From: Paul Cann [REDACTED]
Sent: 05 June 2020 09:45
To: Graham Boston
Cc: Sarah Burrow; James Cook; Chris Martin; Simon Lane
Subject: RE: 9261 - Lineside Industrial Estate, Eldon Way, Littlehampton (P19-439)

From: Paul Cann [REDACTED]
Sent: 18 May 2020 16:30
To: Graham Boston [REDACTED]
Cc: Sarah Burrow [REDACTED]; James Cook [REDACTED]; Chris Martin

From: Graham Boston [REDACTED]
Sent: 01 May 2020 12:03
To: Paul Cann [REDACTED]
Cc: Sarah Burrow [REDACTED]; James Cook' [REDACTED] Chris Martin
[REDACTED]; Simon Lane [REDACTED]
Subject: 9261 - Lineside Industrial Estate, Eldon Way, Littlehampton

Drainage Details Sheet 3
Soakaway Design

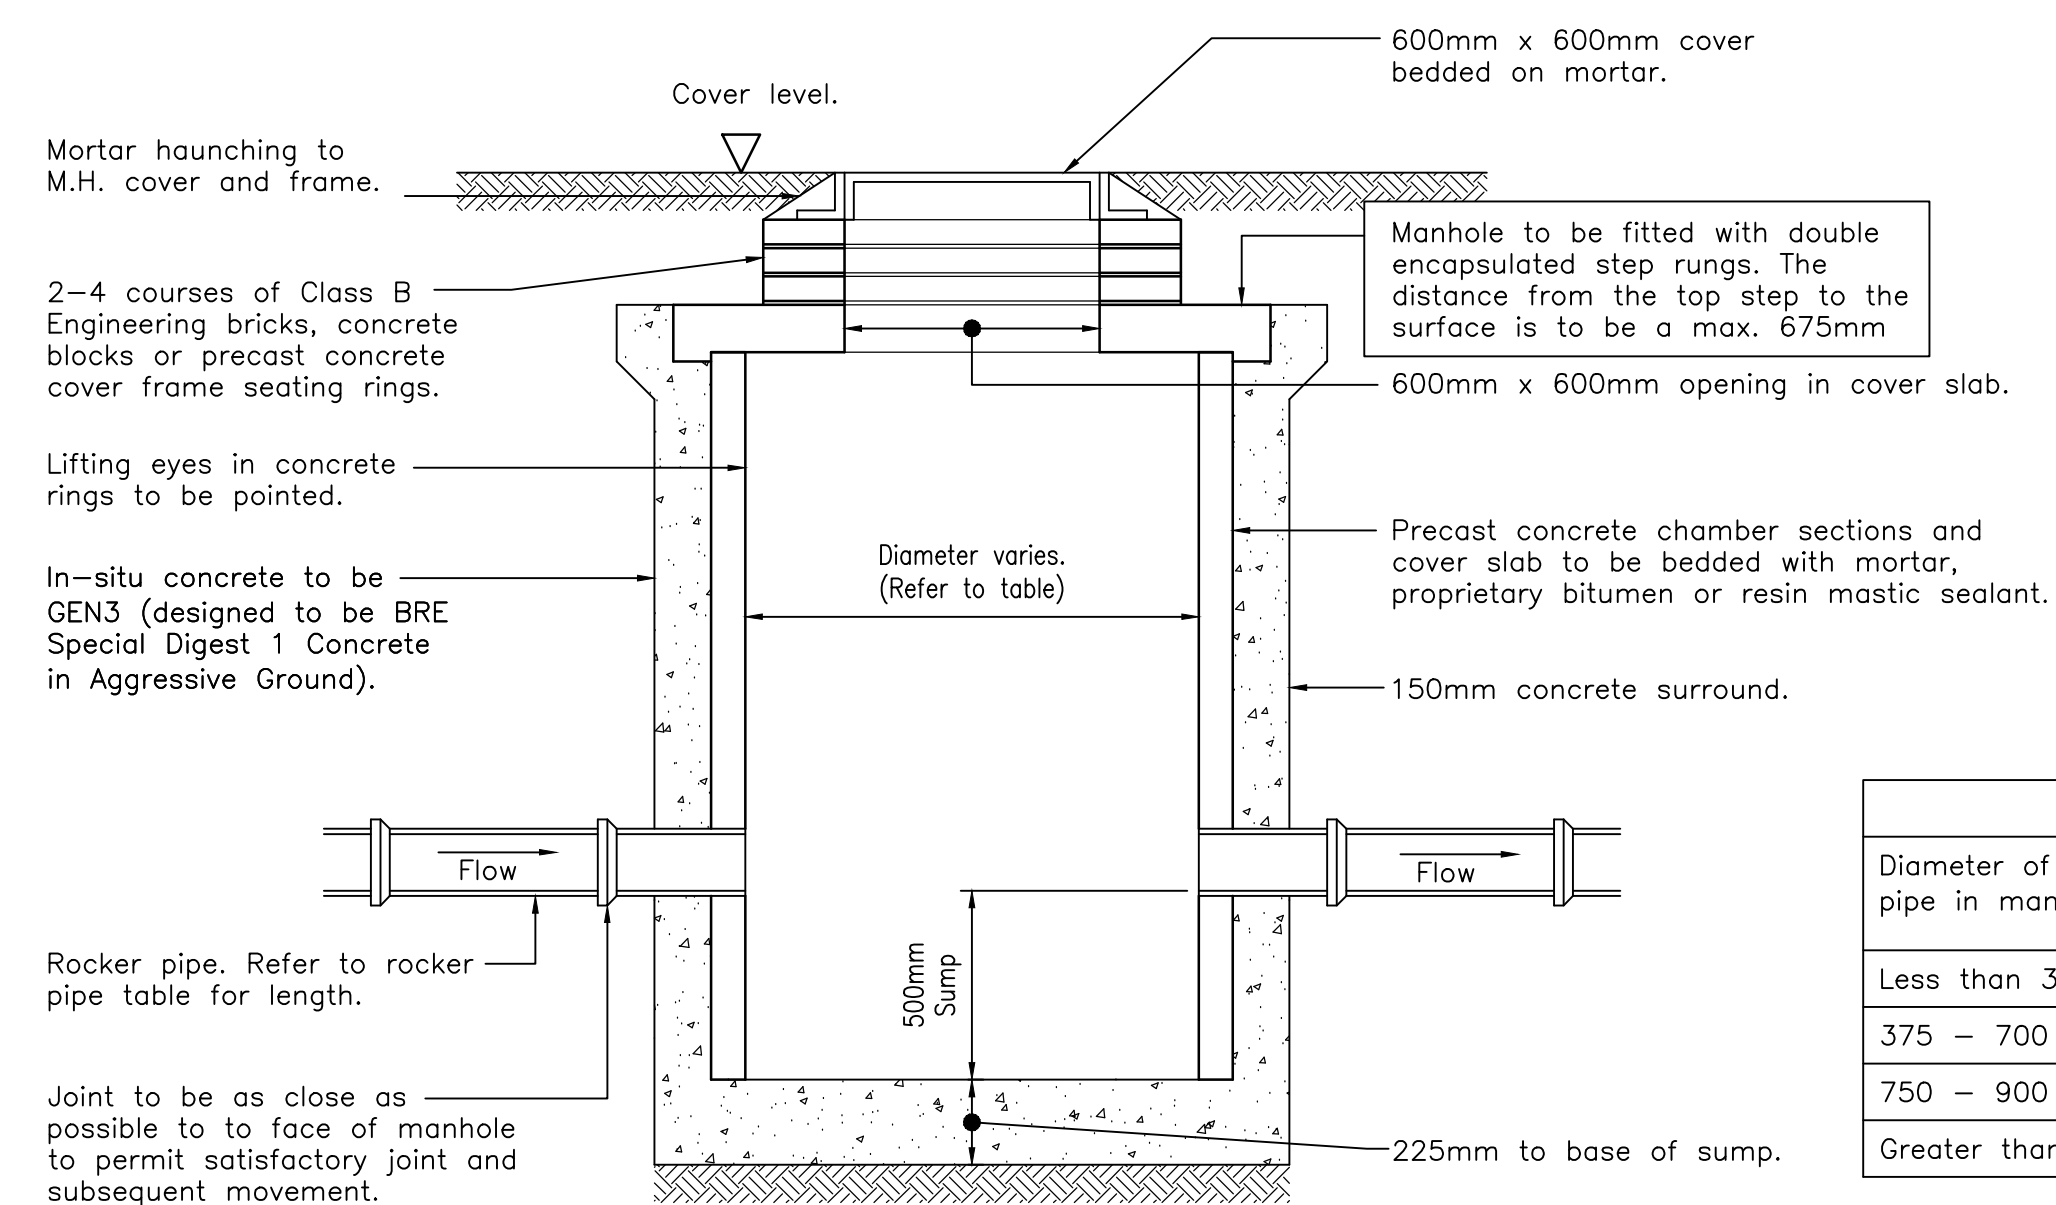
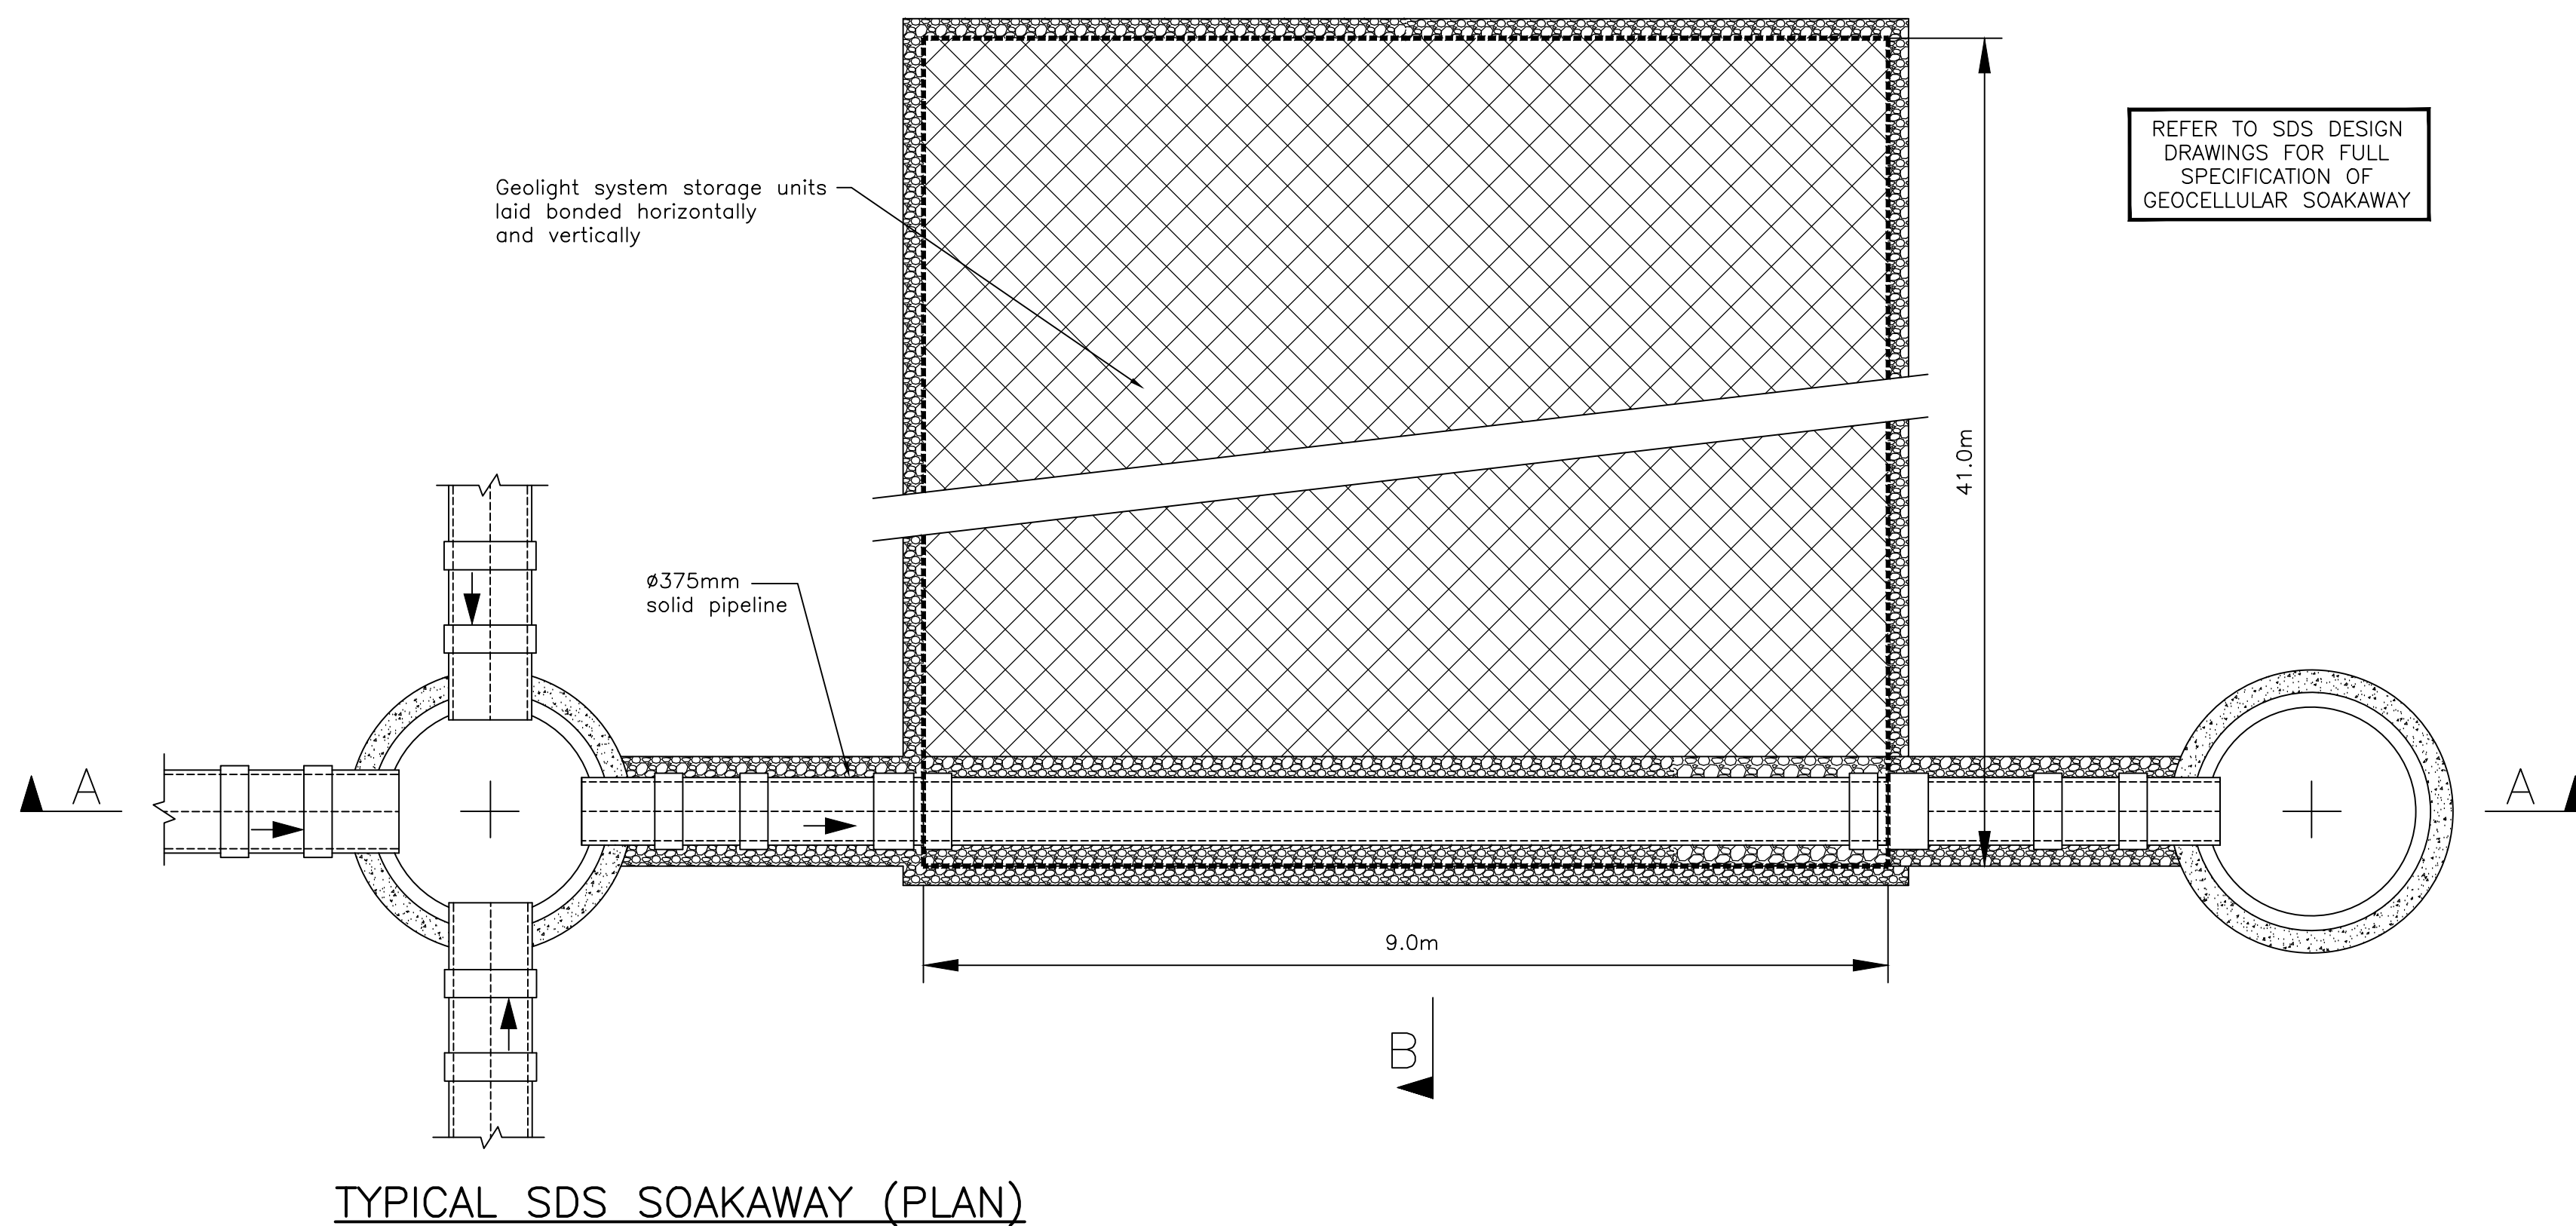
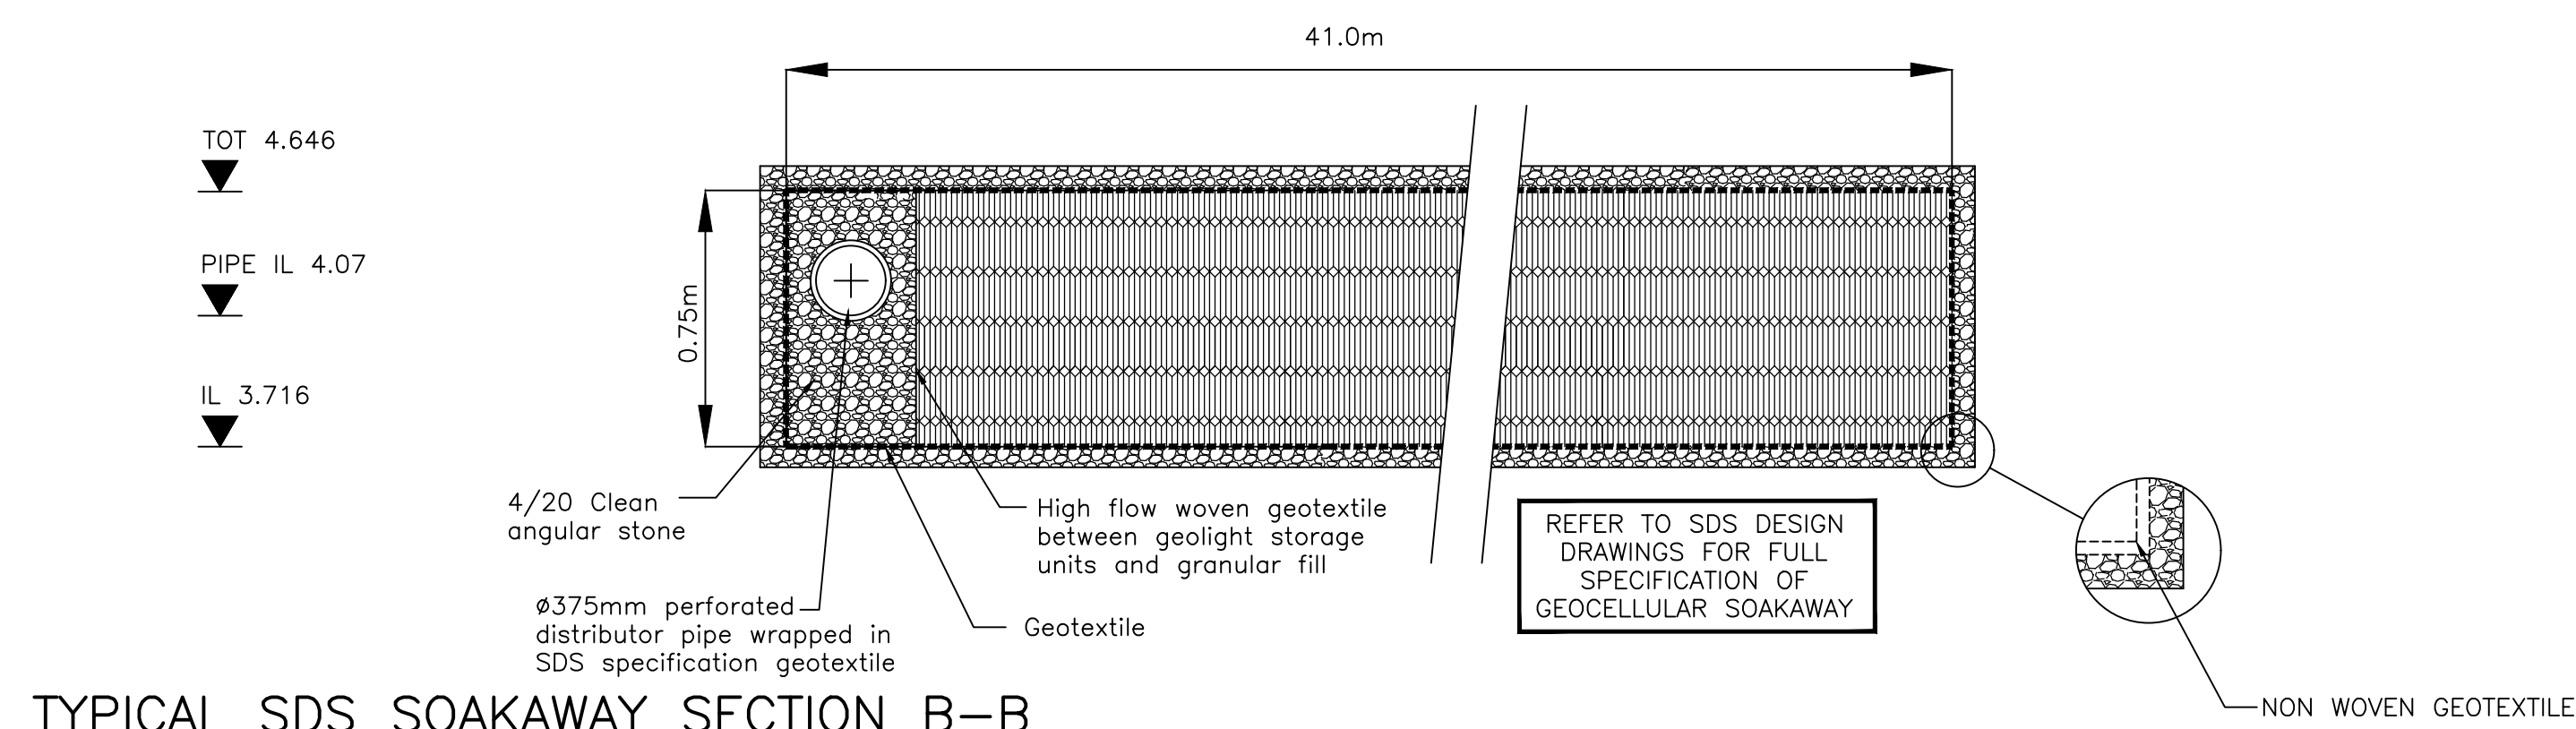
2. I note the half emptying as; 1 in 10 (22 hours), 1 in 30 (28 hours), 1 in 100 (37 hours), 1 in 100+40% (52 hours) – obviously we are only achieving half emptying within 24 hours on the 1 in 10 year event. There is some spare capacity in the crate soakaway and the permeable paving, etc. However, you need to consider overland flow routes/ponding should you experience exceedance with subsequent storms. Please advise, ensuring that there is no detriment to the proposed units and/or neighbouring properties/infrastructure. Also increase plan area of soakaway to reduce half emptying times?
We have been able to slightly increase the plan area of the soakaway to achieve the half drain time for the 1:30 year event which will comply with the requirements set out in the CIRIA SuDS Manual as below. Due to the method of discharge being infiltration to ground it will not be feasible to increase the size of the tank further to accommodate the half drain time for larger storm events.

7. Silt trap manhole construction detail – whilst shown on section A-A of the soakaway. Provide a standalone fully detailed construction detail to cover all silt traps.
Catchpit detail to be added.

13. Granular surround to perforated crate soakaway distribution pipe – specify grading.
Granular surround specified.
14. Is a further gully required within the paving slab footway? ie. near section D-D? Assuming the path falls in that direction.
Ground levels fall towards proposed gully.
